Yorkshire Water Services
Developer Services
Sewerage Technical Team
PO BOX 52
Bradford
BD3 7AY

Your Ref: 2024/91828
Our Ref: A003787

20th August 2024

Premier Inn, St Andrew's Road, Huddersfield, HD1 6SD - Demolition of existing hotel restaurant and erection of additional hotel bedrooms with breakfast room and alterations to the car park and associated works

DRAWING STATUS:		PROJECT STAGE:			
A3		STAGE 3			
SCALE (A1)	AUTHOR	DATE	REVISION	BKPL No.	
1:100	PA	Jun 24	C01	15106	
DRAWING REF: 15106-BKP-XX-XX-DR-C-0511

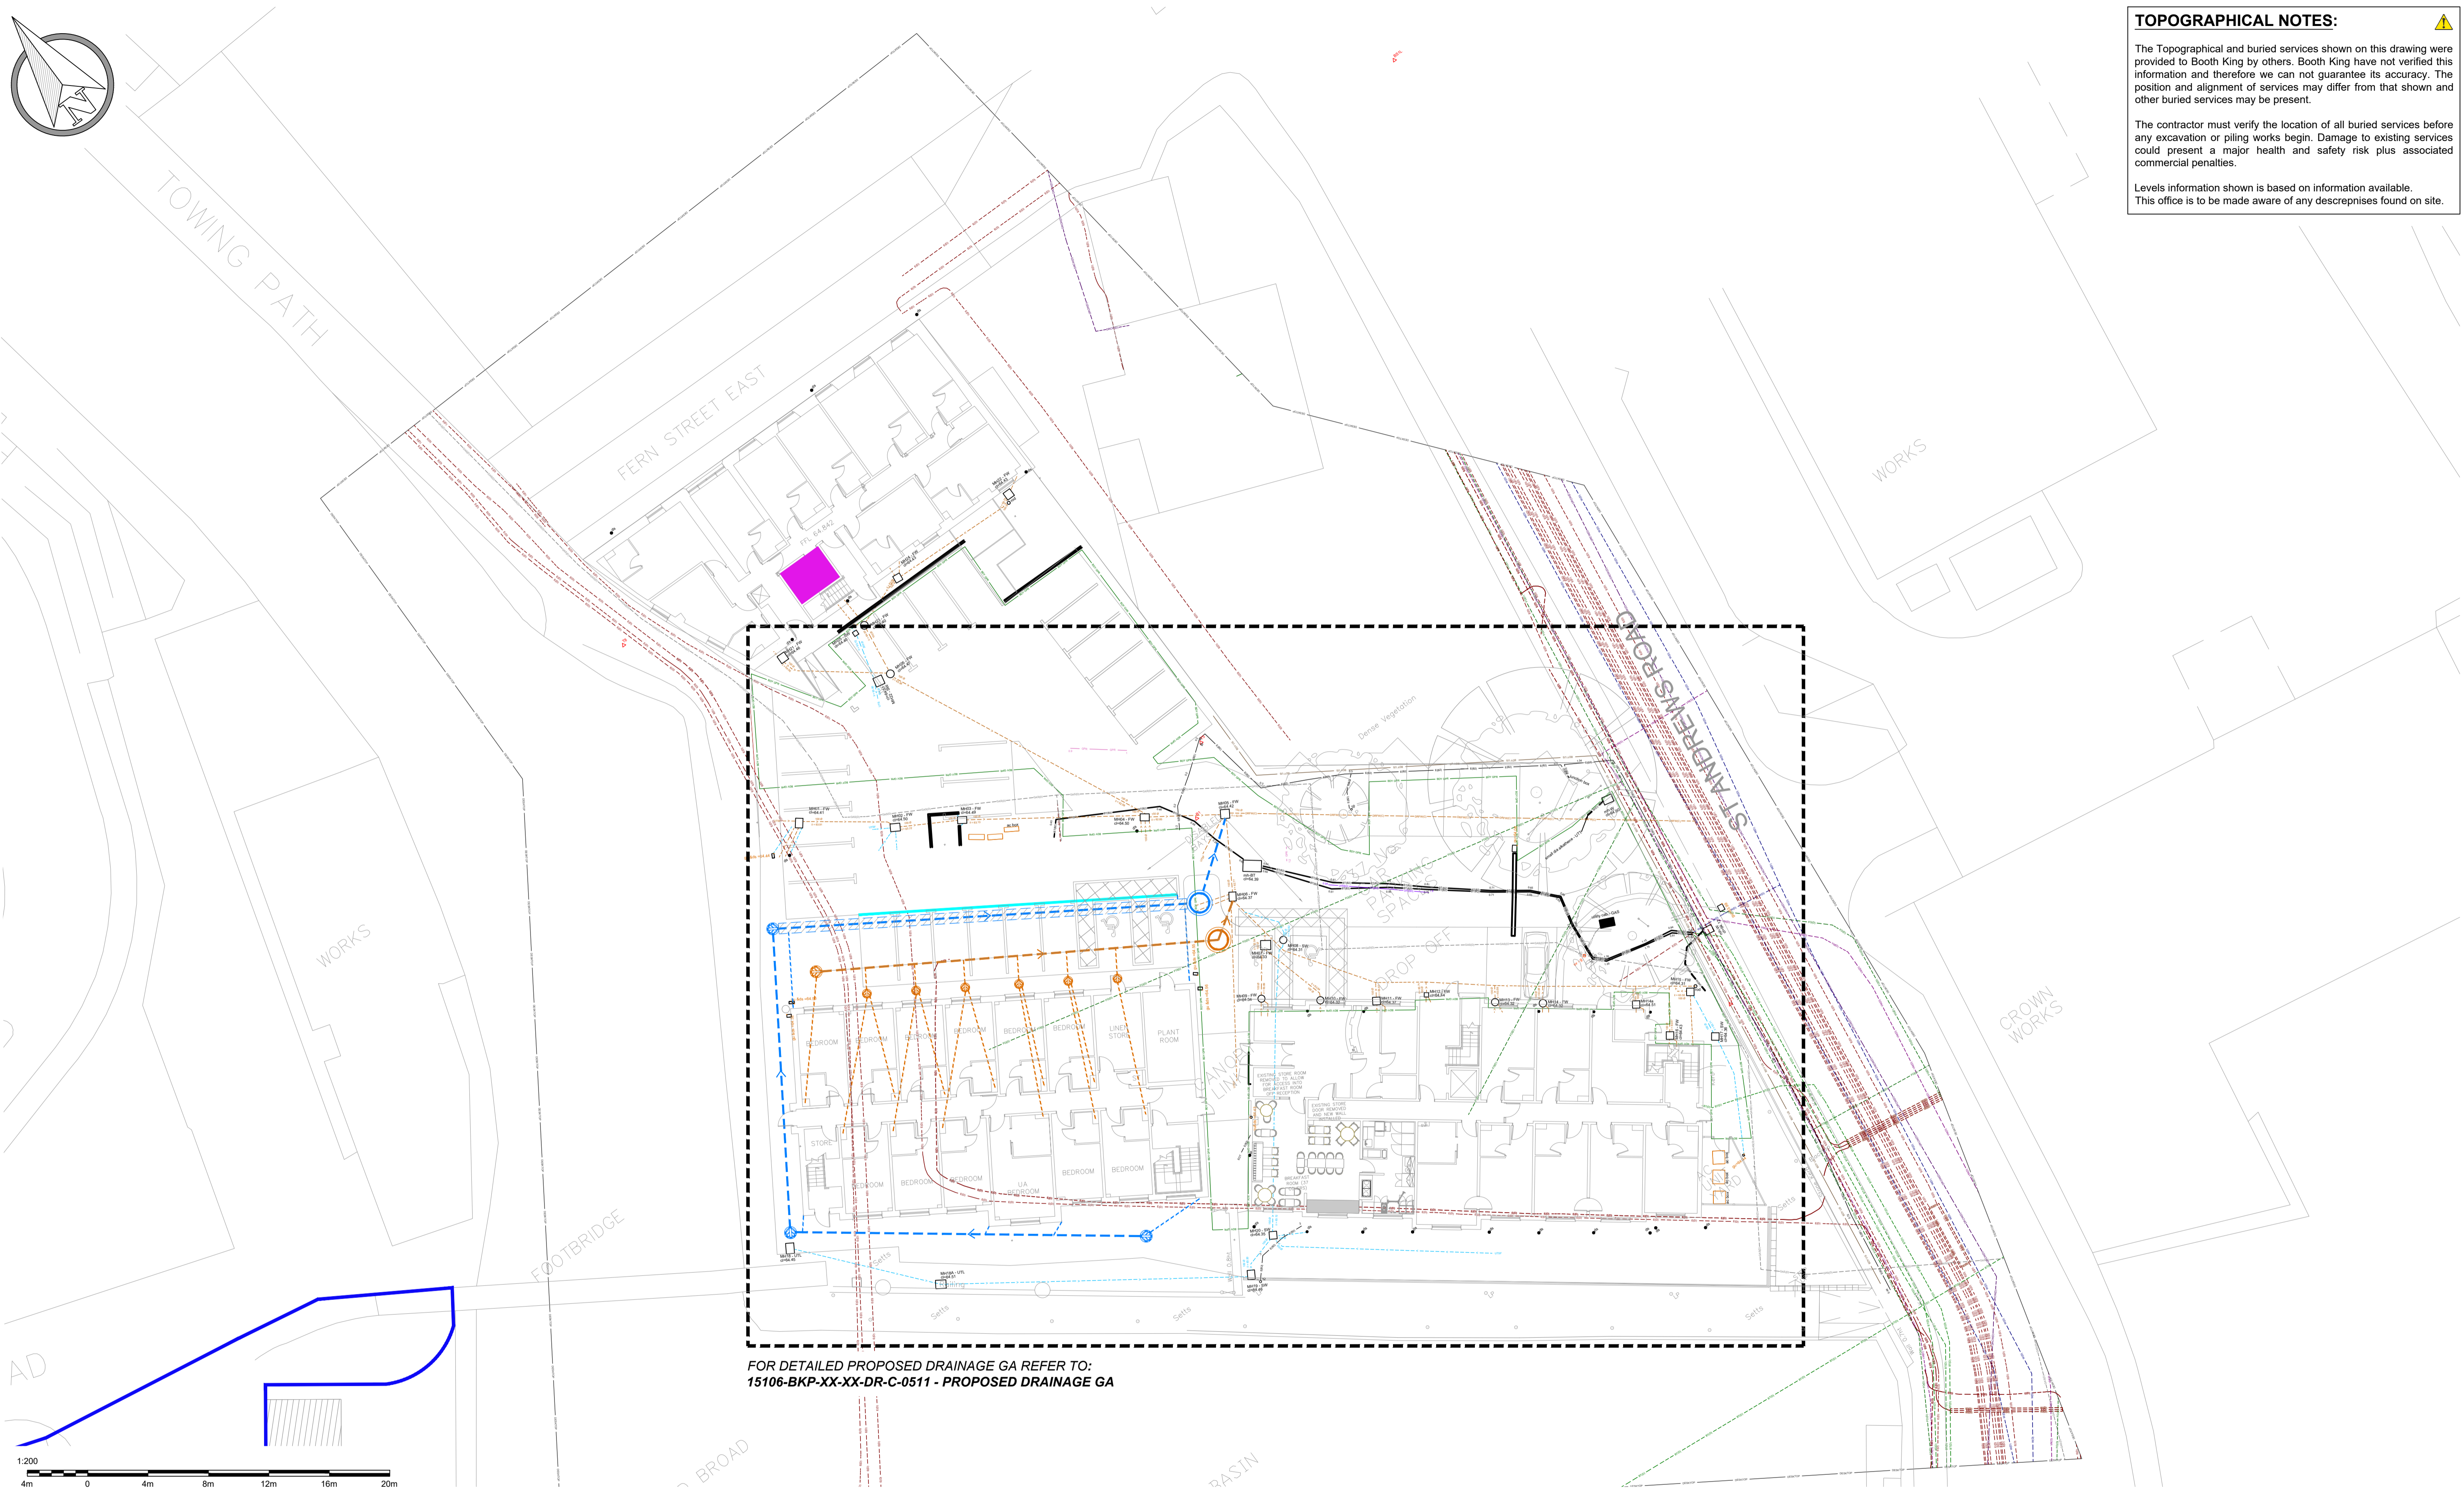
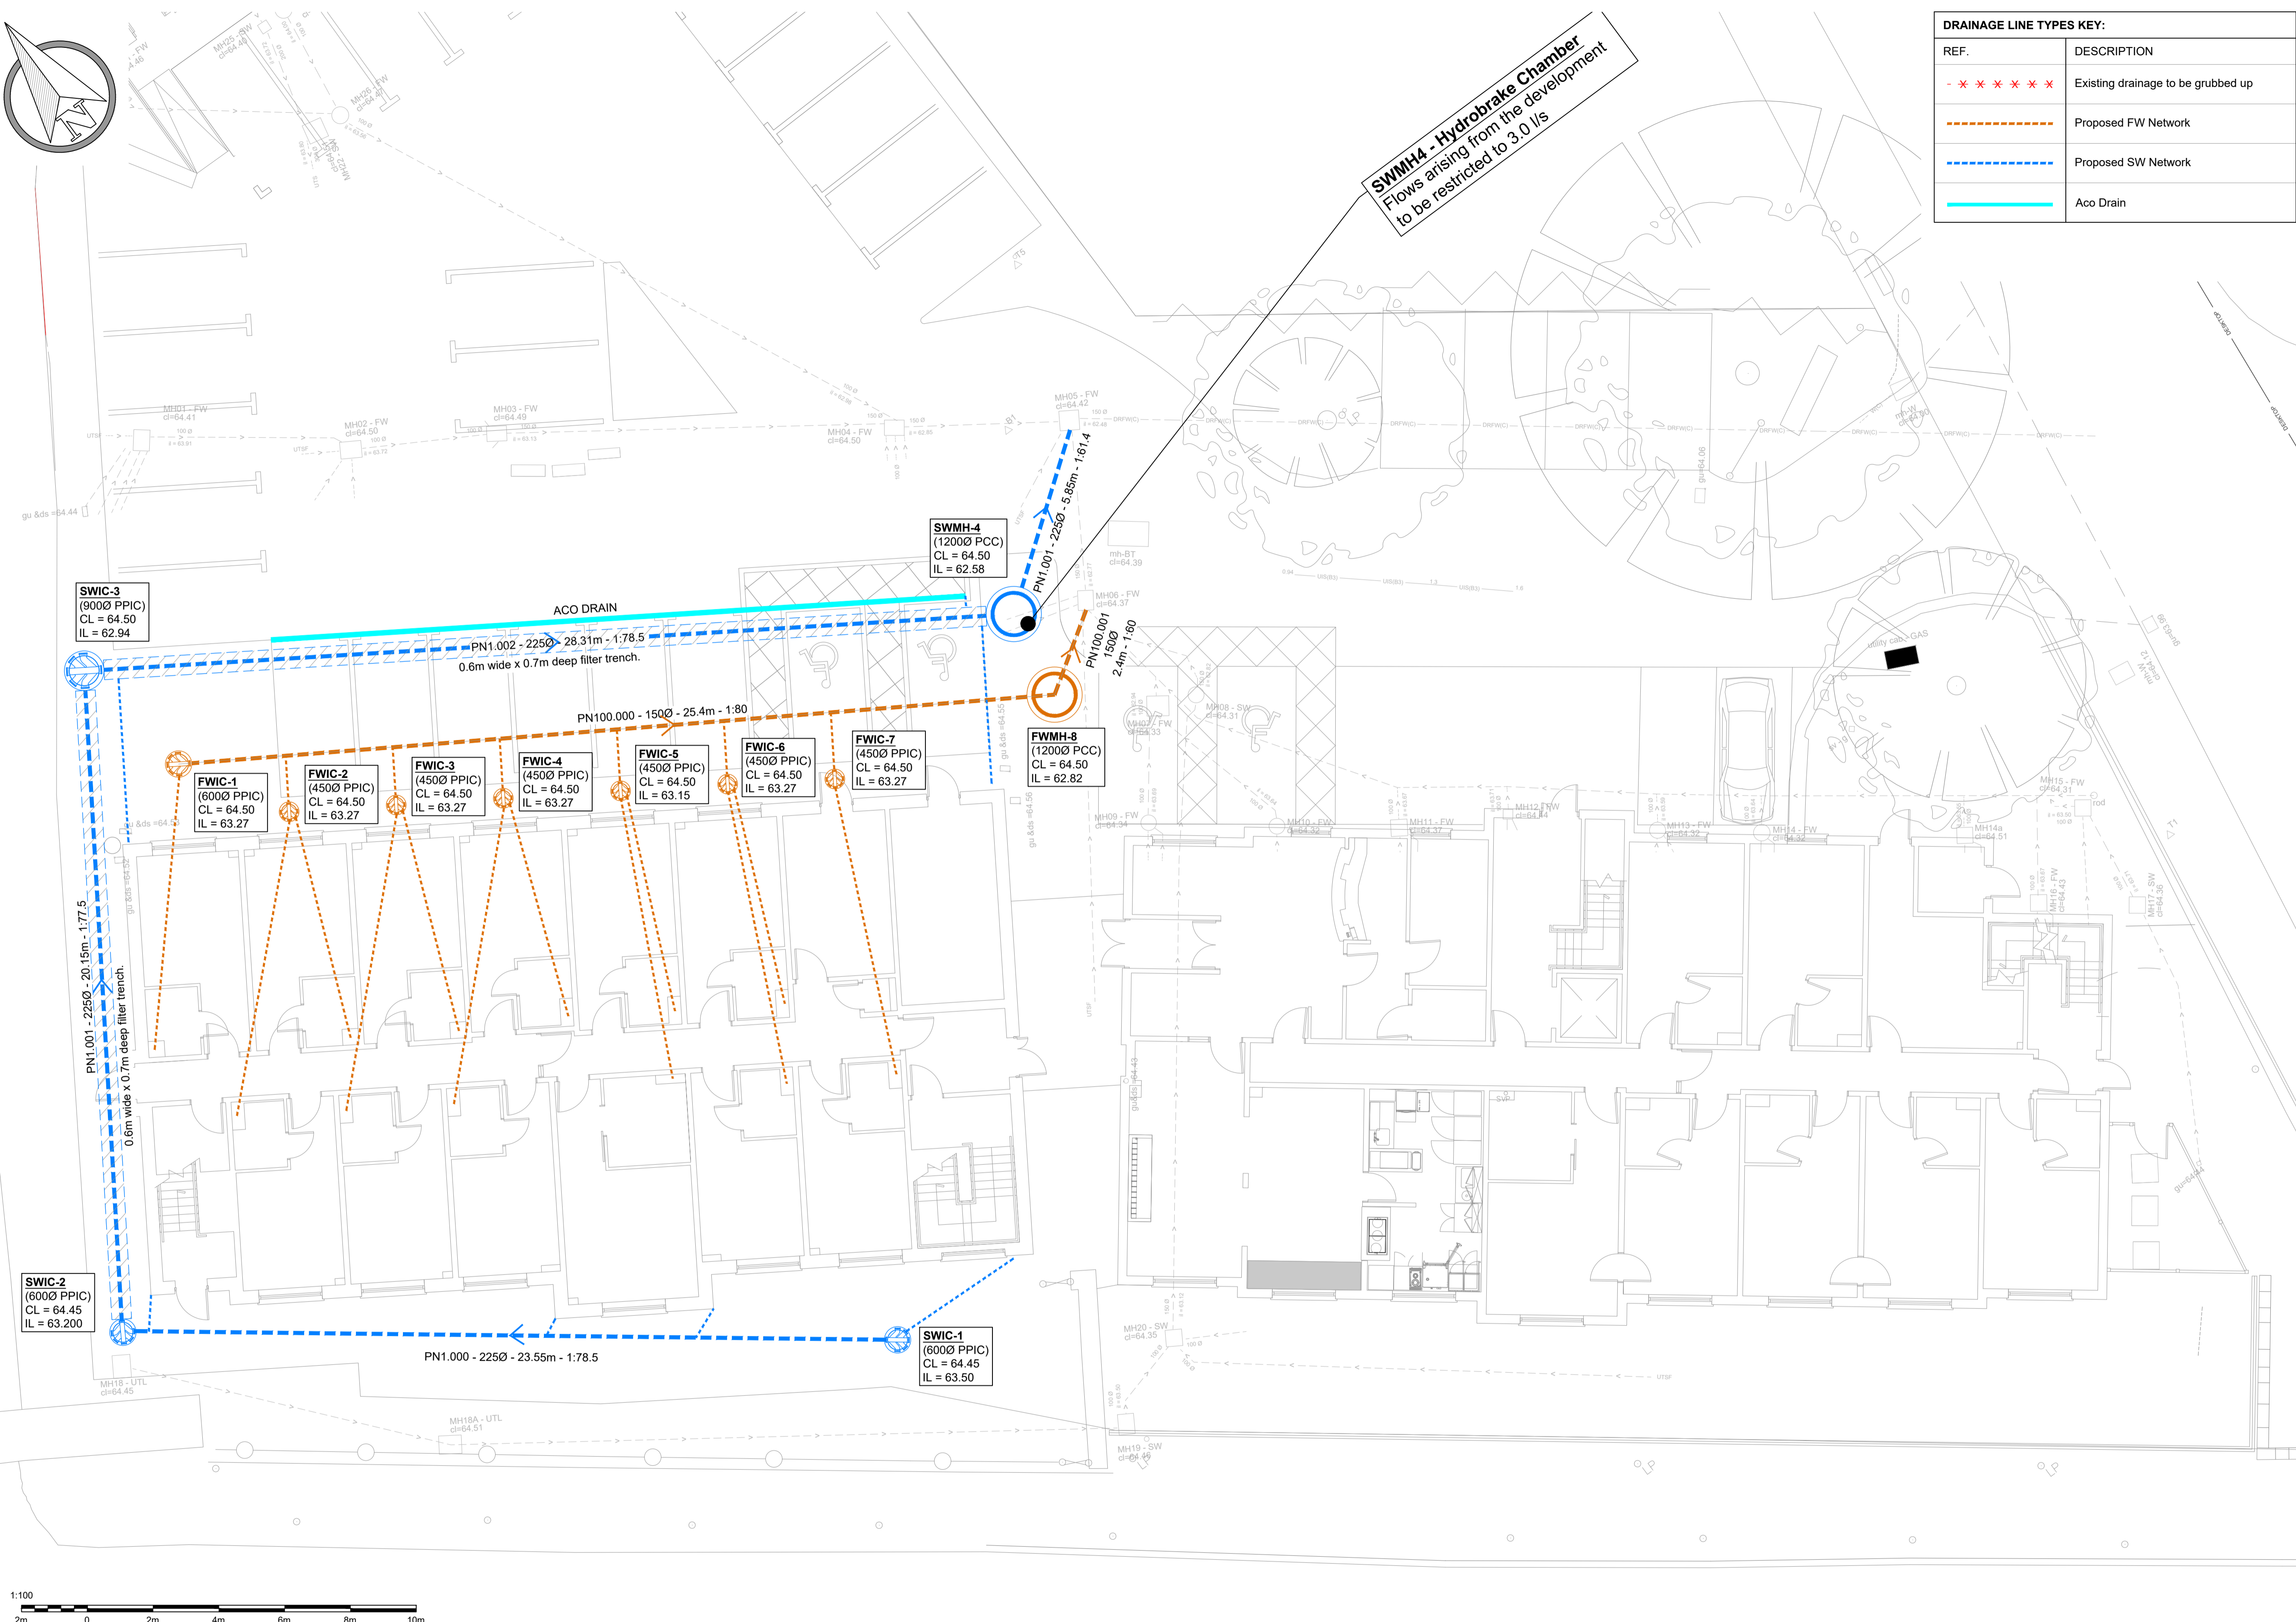
2.) Yorkshire Water has no objection in principle to the drainage details submitted on drawing 'Proposed Drainage GA' 15106BKPXXXXDRC0511(revision C01) dated 19/06/24 that has been prepared by Booth King, namely: -

- a.) The proposed separate systems of drainage on site and off site with combined off-site
- b.) The proposed amount of domestic foul water to be discharged to the public combined water sewer
- c.) The proposed amount of curtilage surface water to be discharged to the public combined water sewer at a restricted rate of 3 litres/second.
- d.) The proposed point(s) of discharge of foul and surface water to the public combined sewer

The development shall be carried out in accordance with the details shown on the submitted plan, "Proposed Drainage GA' 15106BKPXXXXDRC0511(revision C01) dated 19/06/24 that has been prepared by Booth King," , unless otherwise agreed in writing with the Local Planning Authority.
